**RE: Mack Recovery
2510 2nd Street SW
Grading and Drainage Plans
Engineer's Stamp Date: 08/22/25
Hydrology File: M14D042
Case # HYDR-2025-00303**

Based upon the information provided in your submittal received 8/22/2025, the Grading and Drainage Plans **are not** approved for Grading Permit or Building Permit. The following comments need to be addressed for approval of the above referenced project:

CG-101

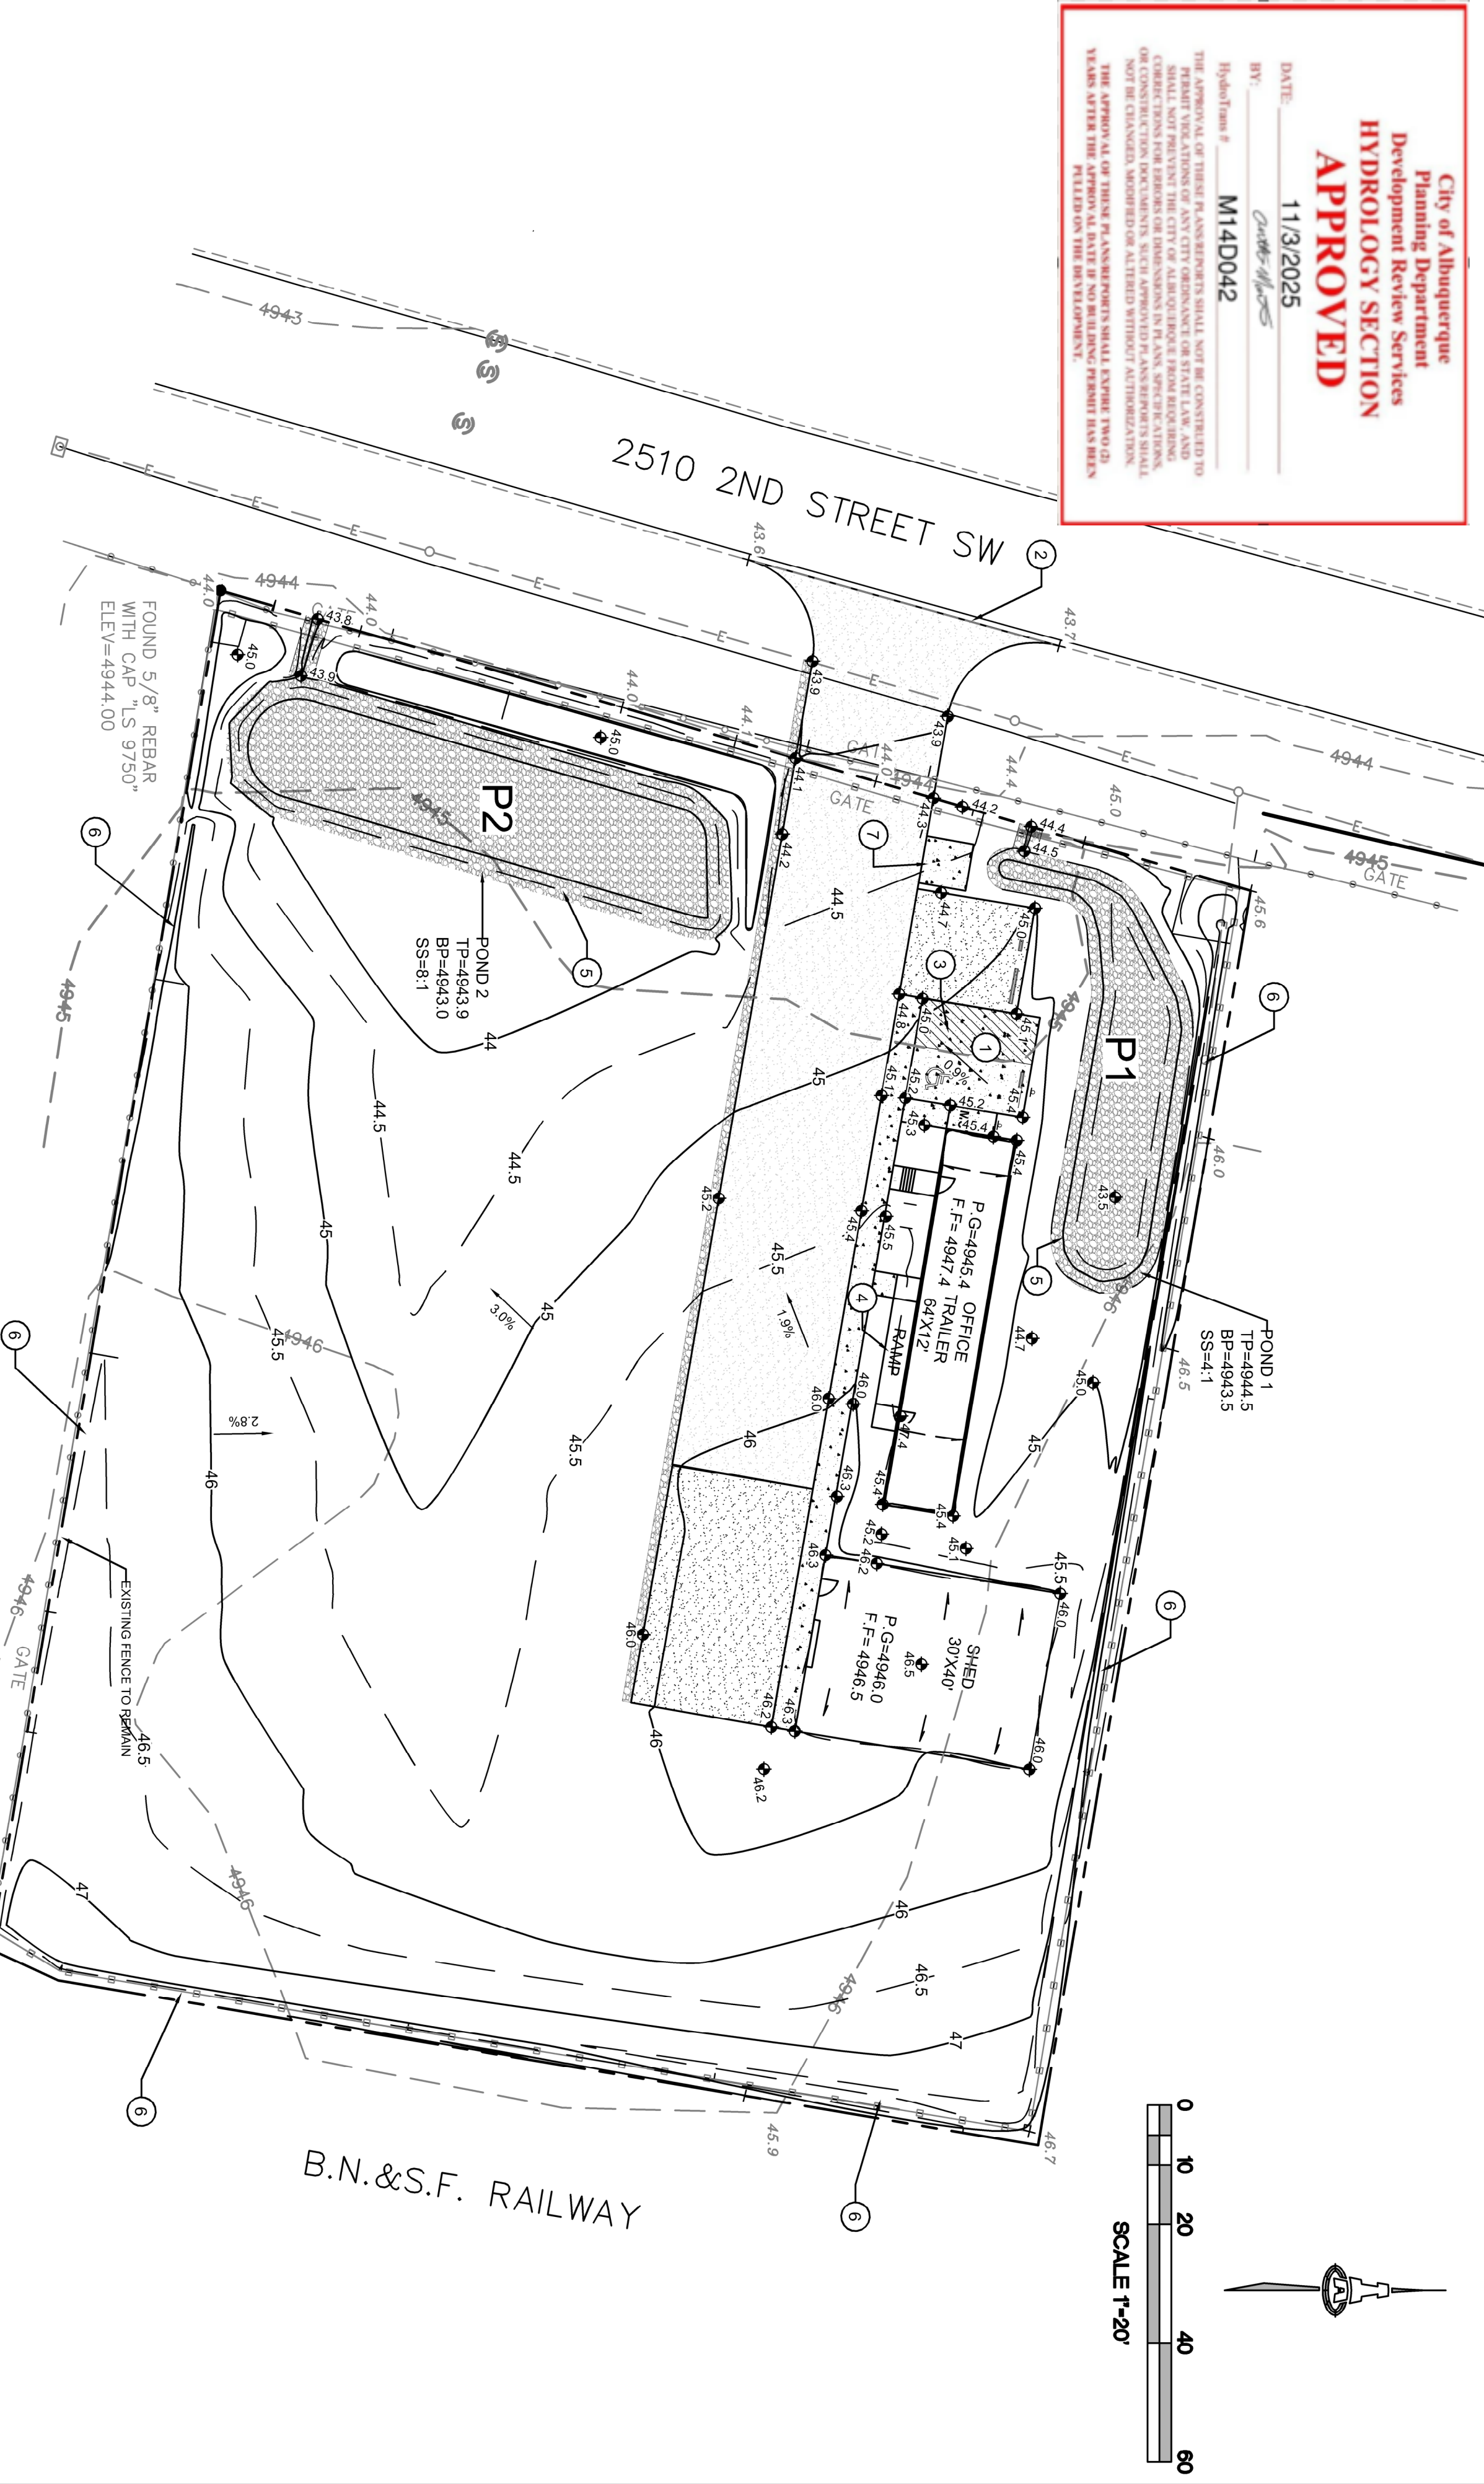
1. Per the IDO, the property owner of the property is responsible for building the adjacent half of 2nd Street SW to include curb & gutter, and sidewalk. The project will have to go to the Development Facilitation Team (DFT) for approval of the Infrastructure List.

2. Please show the sidewalk, curb & gutter on the plan.
3. Please number the ponds and include a label on each with the SWQV and elevation, the 100-year volume and elevation, the peak 100 year inflow and outflow, the spillway crest elevation, the spillway flow depth, and the dam top elevation.

4. Please provide the SWQV calculations for each basin draining to each pond. The stormwater quality ponds need to be sized for the areas draining to them. Show the volume calculation for the 100-year 10-day storm that is to be retained.

5. Stormwater discharges across the sidewalk are not allowed on collector roads and above; provide sidewalk culverts or drain lines through the curb.
6. An SO-19 Permit will be required and should be included on the request. Please include the [standard SO-19](#) notes on the grading plan.

7. Please reference City of Albuquerque standard detail No. 2236 – Sidewalk Culvert with Steel Plate Top at the sidewalk culvert.
8. A perimeter wall or barrier around the development is required to contain the 100-year 10-day storm developed runoff. Since the existing chain link fence will remain, please show a berm or equivalent around the perimeter to avoid discharge from this site to adjacent properties.

9. Show FP and FF elevations for the structures. The Vally Area recommendation is to elevate the pad a minimum of 18" above the edge of pavement or roadway or 1 foot above the 100-year 10-day stormwater surface elevation.
10. Add the Downstream Capacity information per 6-7(A) of the DPM. There are no public storm drain facilities in 2nd Street SW nor curb and gutter and therefore no hydraulic capacity.
11. Please state if there are any off-site flows that will need to be accepted and quantified.
